Application Ref: EN010125

Our Reference: DIO10053433

**NOTICE OF ACCEPTANCE OF AN APPLICATION FOR A DEVELOPMENT CONSENT ORDER BY THE PLANNING INSPECTORATE (ON BEHALF OF THE SECRETARY OF STATE FOR ENERGY SECURITY AND NET ZERO) UNDER SECTION 56 OF THE PLANNING ACT 2008**

**DOGGER BANK SOUTH OFFSHORE WIND FARMS PROJECT**

Figure 15: Staxton Wold RLoS 396m amsl

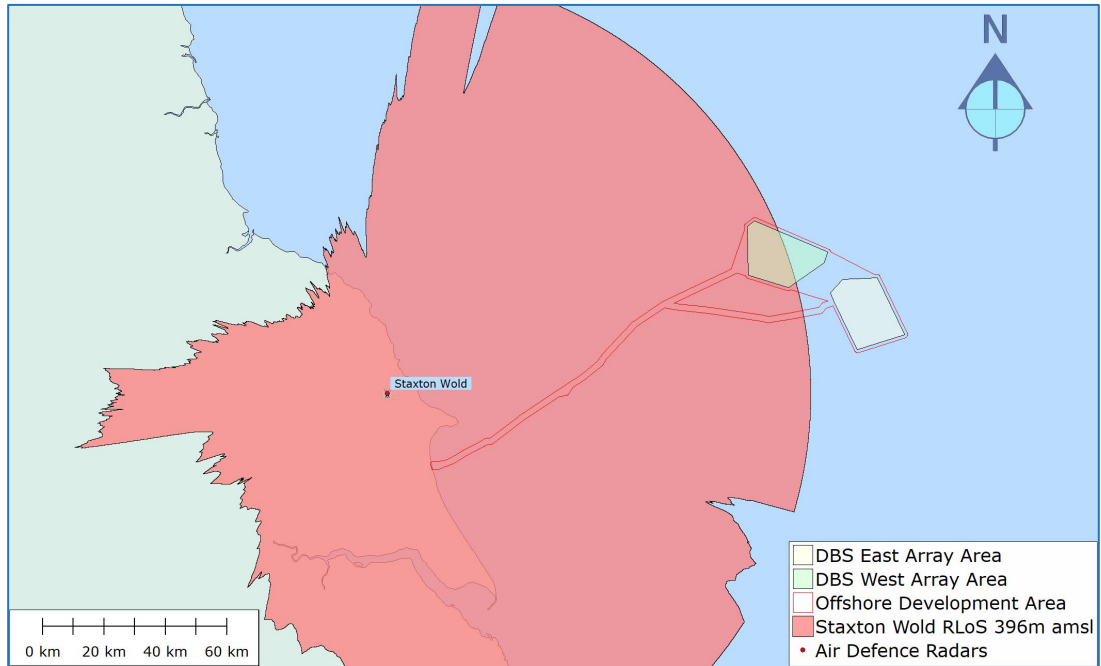
At this time the MOD must **object** to the proposed development on the basis that the scheme would have a significant and detrimental impact on the effective operation and capability of air defence radar deployed at RRH Staxton Wold.

The proposed turbines would be located approximately 123.2km from, detectable by, and will cause unacceptable interference to the AD radar at RRH Staxton Wold.

Our assessments have determined that, when operational, the proposed wind farm will cause unacceptable and unmanageable interference to the effective operation of air defence radar deployed at RRH Staxton Wold.

Therefore, on the basis of the information provided, and until a suitable mitigation scheme has been submitted, assessed, and accepted, the MOD must **object** to this proposal due to the impact it will have on the AD radar at RRH Staxton Wold.
